**Sent:** ✓ 27 September 2013 16:43  
**To:** Planning  
**Subject:** For the Attention of Miss K. Phillips - Your Ref: S6/2013/1886/FP  
**Attachments:** Copy of Land Registry Title OS Plan Ref TL 3003 Sec B.pdf

**Re: Erection of Two Storey Side and Rear Extension, Loft Conversion and Front Bay Windows at 5 Orchard Close, Cuffley, Potters Bar**

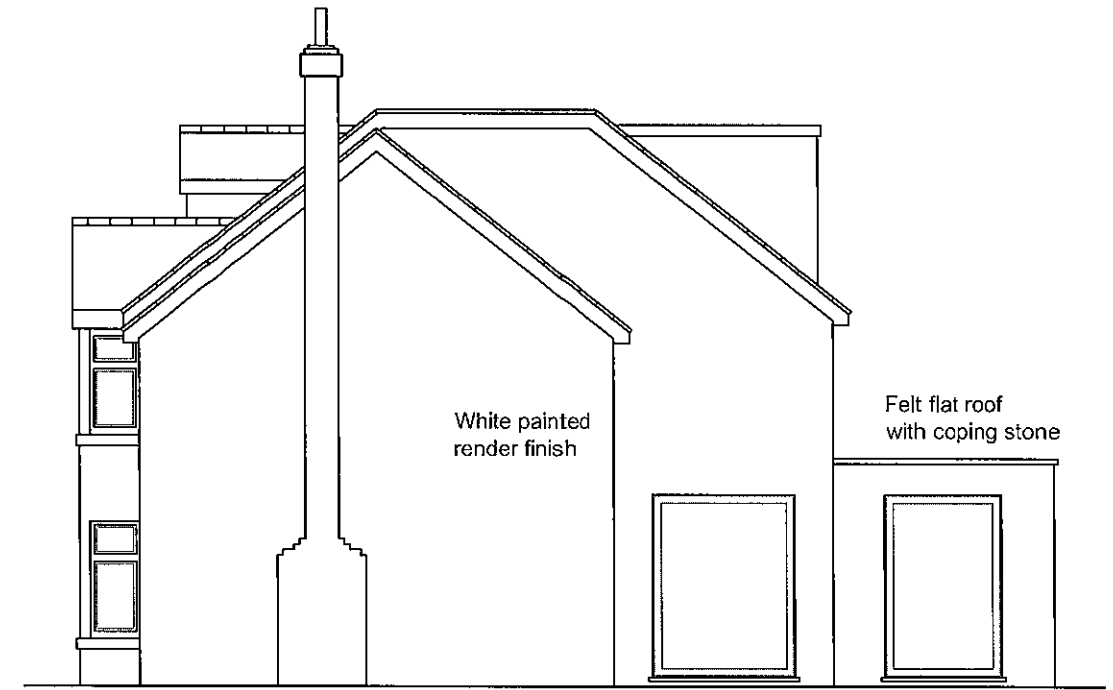
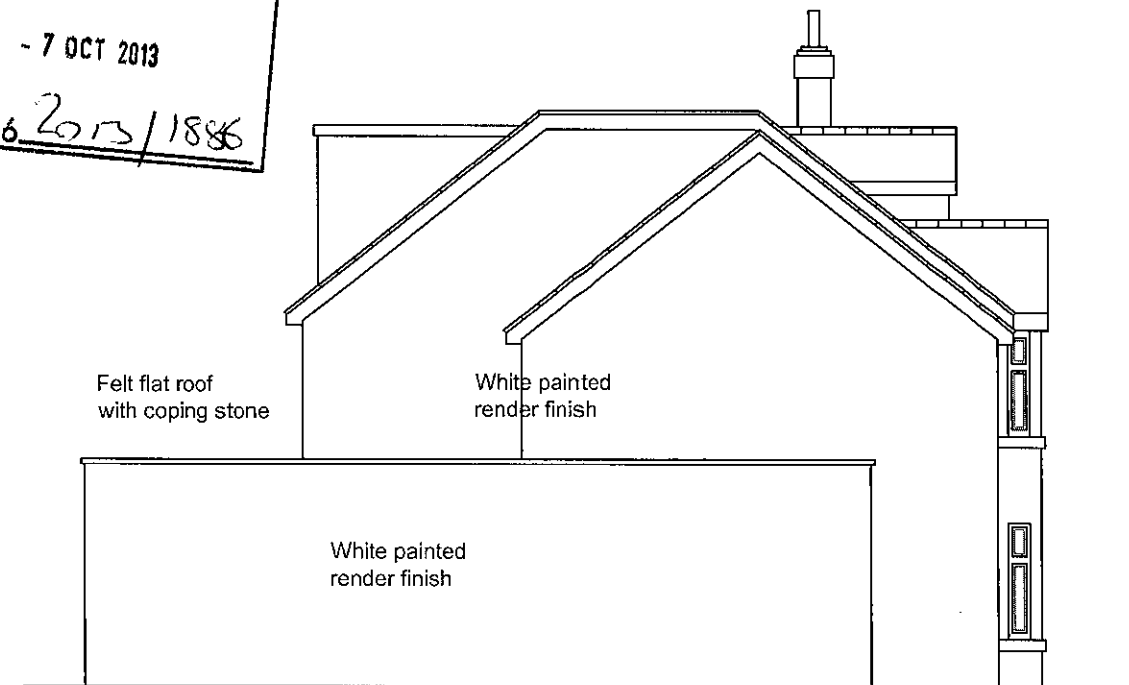
Firstly, we have lived in our current property No 6 Orchard Close, which adjoins the proposed development, for over 25 years and have seen many changes to the properties in Orchard Close during this time. However, this proposal is by far the largest and we feel that the resultant property would be wholly out of keeping with the rest of the homes along the road. No 5 Orchard Close is already sited in an elevated position at the head of the culdesac and this height will be greatly accentuated by the mass and appearance of the proposed effectively three storey building. The current sloping roof will be protruded by dormers both to the front and rear adding height to every aspect of the house. As a result, it will appear to tower above the other properties in the road and, in particular, will dwarf the neighbouring chalet bungalow that comprises No 4, which is already lower than No 5 due to the natural lie of the land.

In conclusion, we consider that the proposed application represents over-development of the site. In particular, we have concerns for our neighbours' and ourselves regarding the designation of the boundary to No 5, the potential impact of the double storey side extensions and the lack of provision for parking. Please note that these concerns are based upon a very good understanding of the potential impact of the proposal given the substantial amount of building works that have already been undertaken, and continue to take place, on the site which, according to the applicant, are covered by the "permitted development" rules. It appears to us that the level of the proposed development on the site is far more than we would have envisaged would be permitted under the current planning regulations.

- (i) We were to be assured that the proposed development is to be undertaken wholly within the boundaries of the applicant's own land, and
- (ii) The side extensions were to be reduced to single storey, thereby making the whole property less imposing, and
- (iii) The front left hand side extension were to form a double garage with an adequate driveway to resolve, to some degree, the anticipated parking difficulties.

ADDRESS : 5 ORCHARD CLOSE, EN6 4QD	
PROJECT TITLE : EXTENSIONS AND LOFT	
DRAWING TITLE : PROPOSED	
drawn MIDAS PLANNING	scale 1 / 100 @ A3
date JULY 2012	dwg no. 378/03

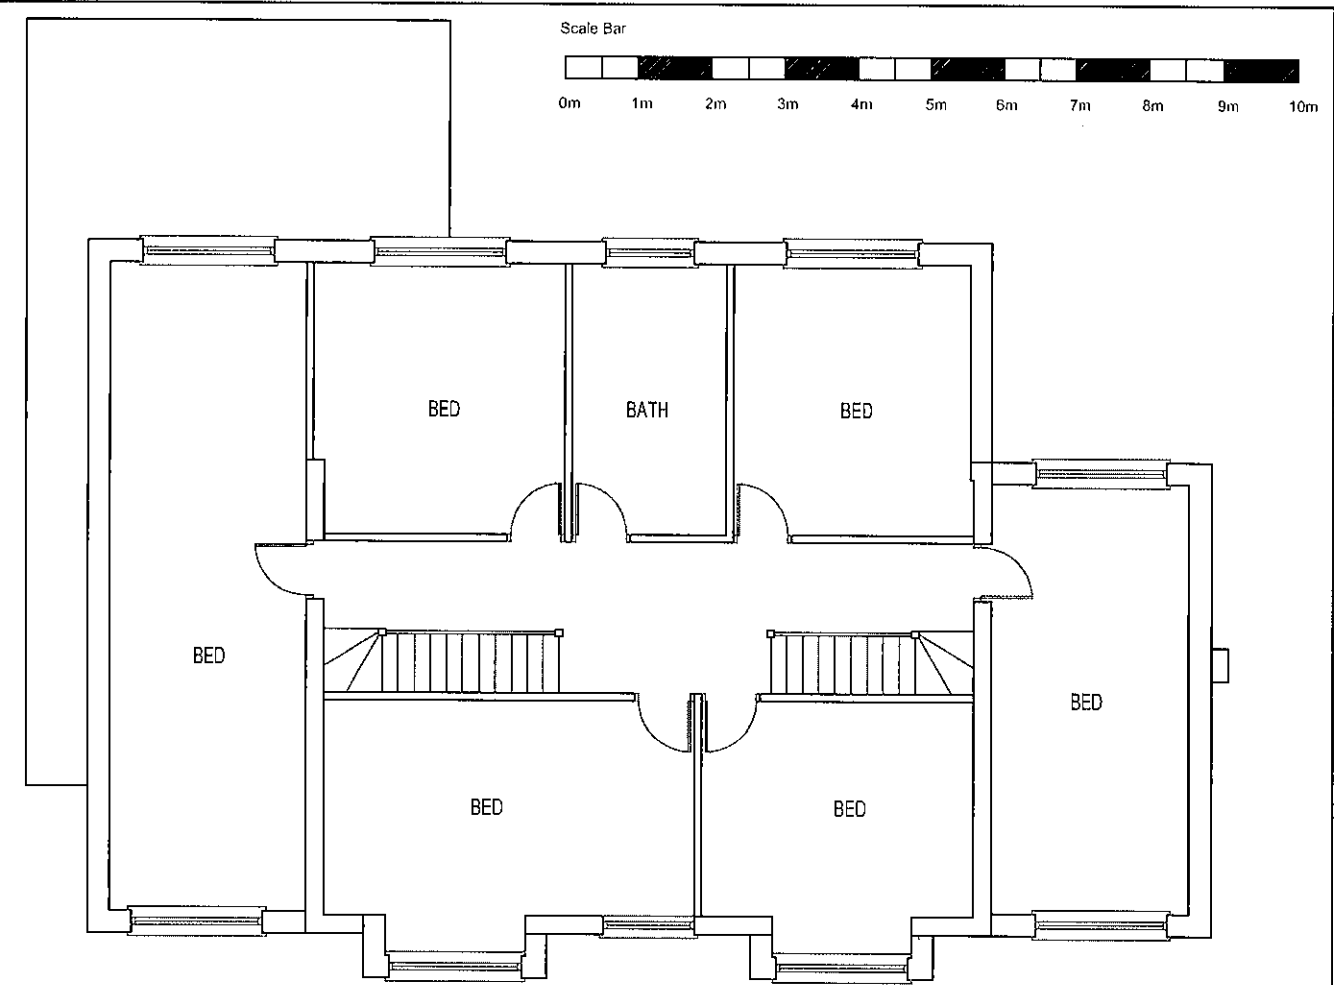
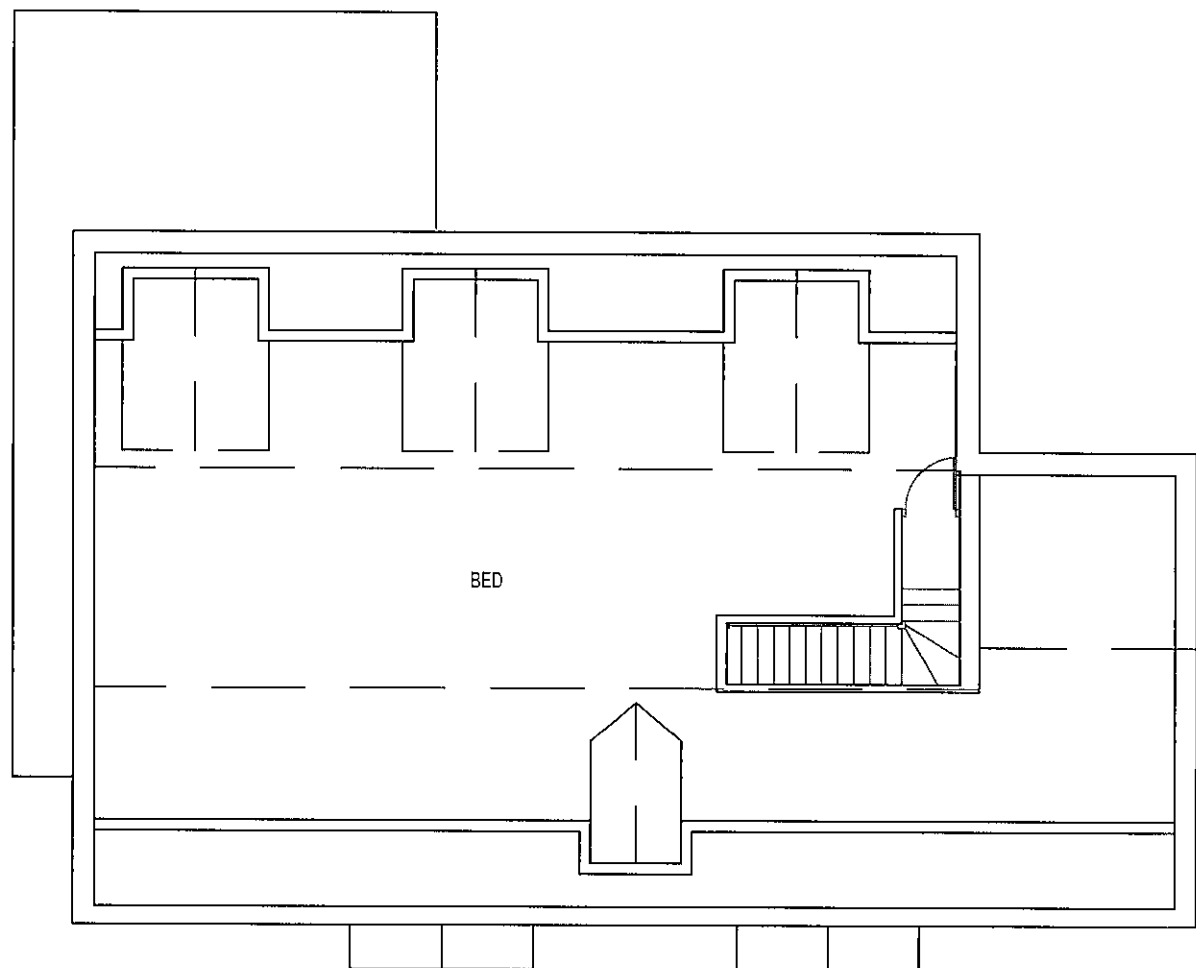
We would also like to mention that the "existing property" (being the building so referenced in the planning application) had a double length garage to the left hand side whereas the proposed development, despite having provision for seven bedrooms, has no provision for any garage. However, we notice from the submitted 'Householder Application for Planning Permission' that it is stated that the proposed works will not affect existing car parking arrangements – this is clearly incorrect. It is also stated that no trees or shrubs will need to be removed or pruned in order to carry out the application – how is this possible? We can only assume that it is not intended to turn the former front garden over to hard standing but rather to replace the front lawn and shrubs that have already been removed as a result of the groundworks undertaken to date. In either case, the property will have very little frontage on which to accommodate cars, even if the whole of the front garden was to be taken over as hard standing – something which would also be out of keeping with the rest of the properties in the road and surrounding area which all have, at the very least, green verges to

their frontages. This greenery is very important for the local wildlife and birds and should be maintained wherever and whenever possible. A seven bedroom property implies a large family residence with the potential for several vehicles, so where will they be parked? It would be extremely difficult to accommodate these, and any additional visiting vehicles, in the road without blocking the access to other properties. We envisage that this would be a particular problem for residents, visitors and delivery vehicles alike due to the very limited other parking opportunities where No 5 is sited at the head of the culdesac, which is regularly used as a turning circle.

ADDRESS : 5 ORCHARD CLOSE, EN6 4QD	
PROJECT TITLE : EXTENSIONS AND LOFT	
DRAWING TITLE : SITE PLAN	
drawn MIDAS PLANNING	scale 1 / 200 @ A3
date OCT 2013	dwg no. 378/05

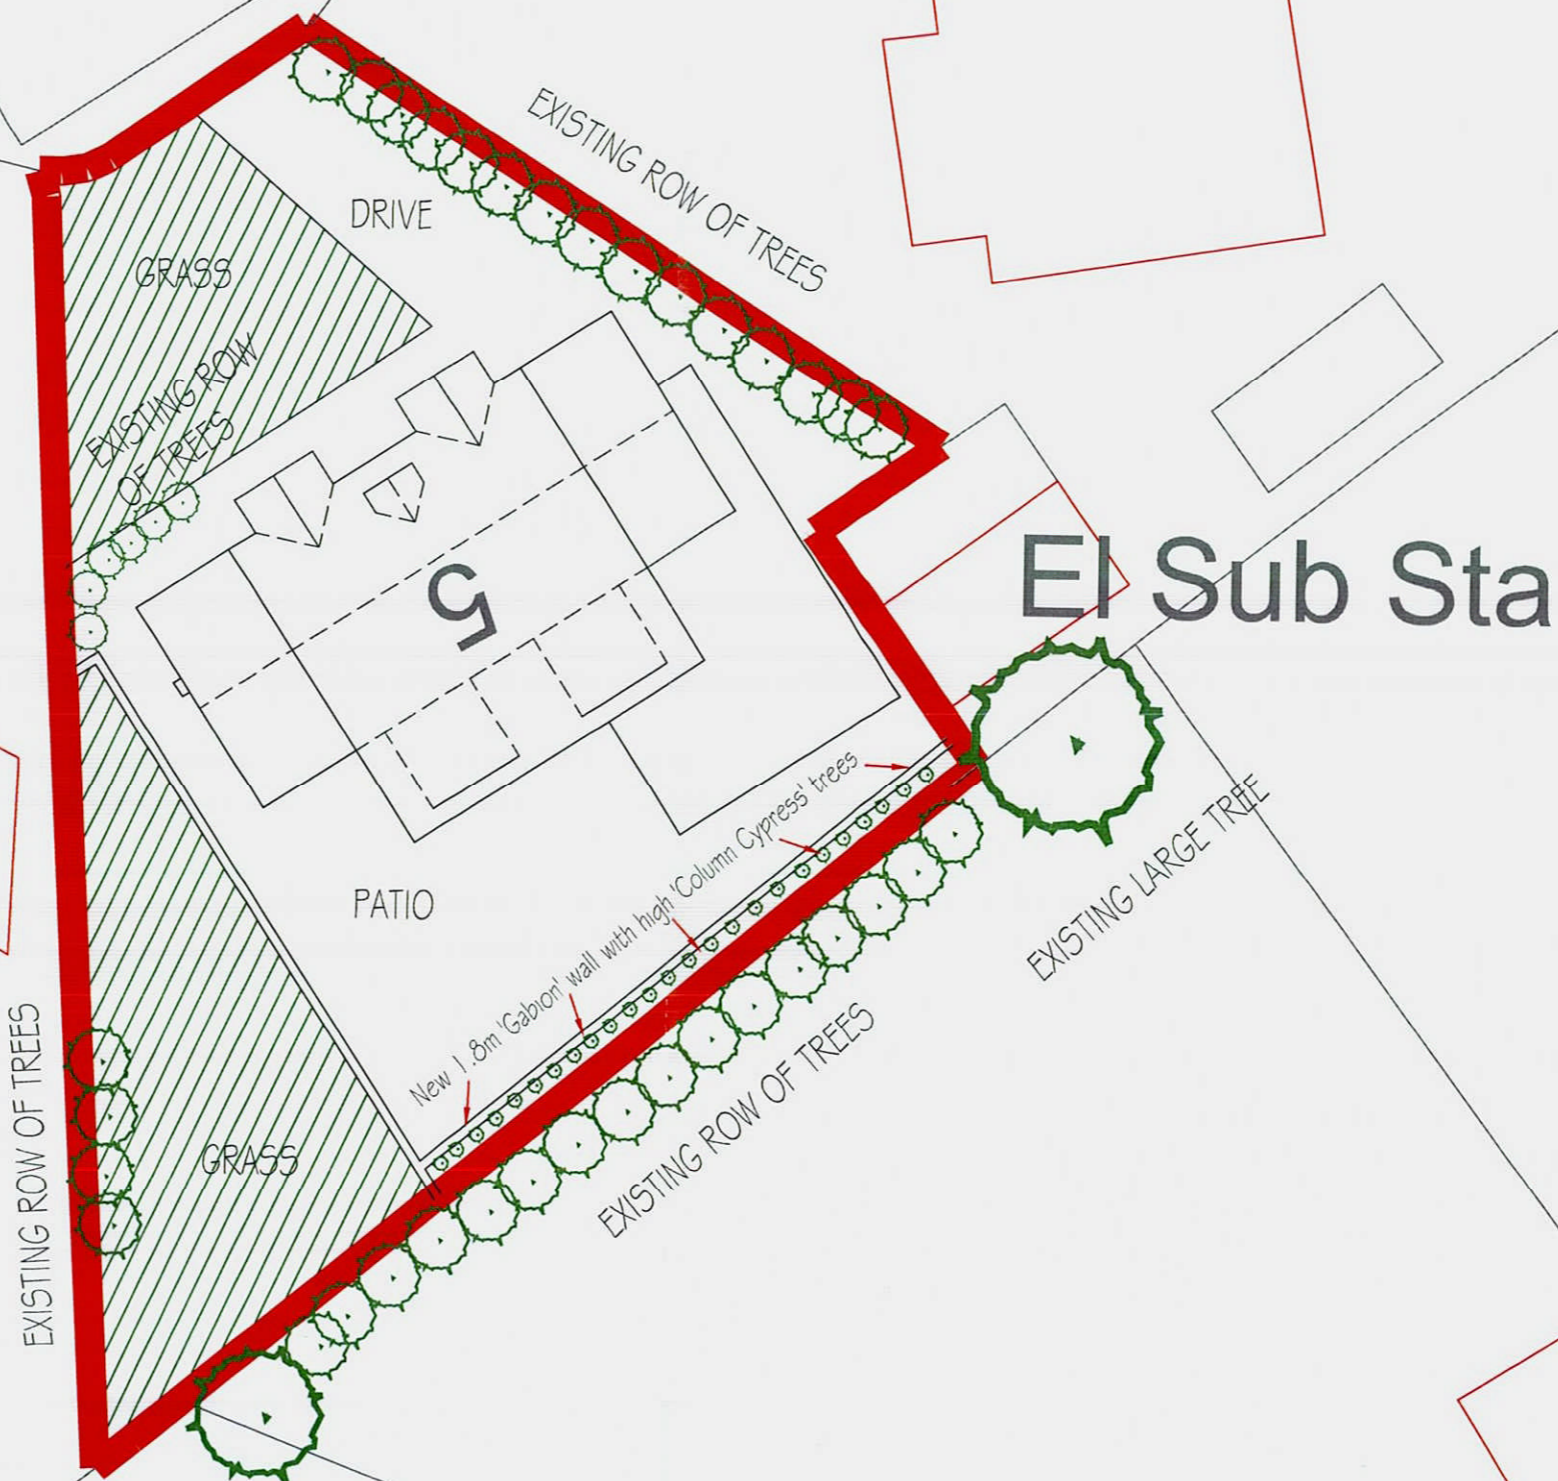
We would also question the boundary line as it is drawn on the submitted plans between Nos 4 and 5. Since we have lived here, both properties have changed hands twice and we have always understood that the boundary line to No 5 on that side of the property followed the edge of the driveway to No 5 at the front, along the existing garage at No 5, travelling back alongside the right hand side of the electricity sub station to the garden border with 36 Kingsmead. We attach a plan from H.M. Land Registry in respect of our own title which clearly indentifies a separate strip of land leading to the sub station giving them access for maintenance purposes. Our understanding is that this strip, as marked in red on the attached plan, does not form part of the land title relating to No 5.

Furthermore, there is a distinct reduction in land height along the border between this strip of land and No 5 where there are shrubs and trees that have never been maintained by previous owners of No 5. The submitted plans incorrectly show the boundary for No 5 to be sited as the left hand boundary of the strip of land giving access to the sub station. In our opinion, therefore, the proposed side extension would be built right along the actual boundary line between No 5 and the sub station, not within the applicant's own land as shown by the plan submitted for planning approval purposes. We therefore question whether appropriate permission has been sought from the electricity company concerned to build on this boundary. We would also point out that the flank wall on that side of the proposed structure would be a substantially high and imposing brick wall facing the property at No 4 that would no doubt interfere with that property's enjoyment of natural light.
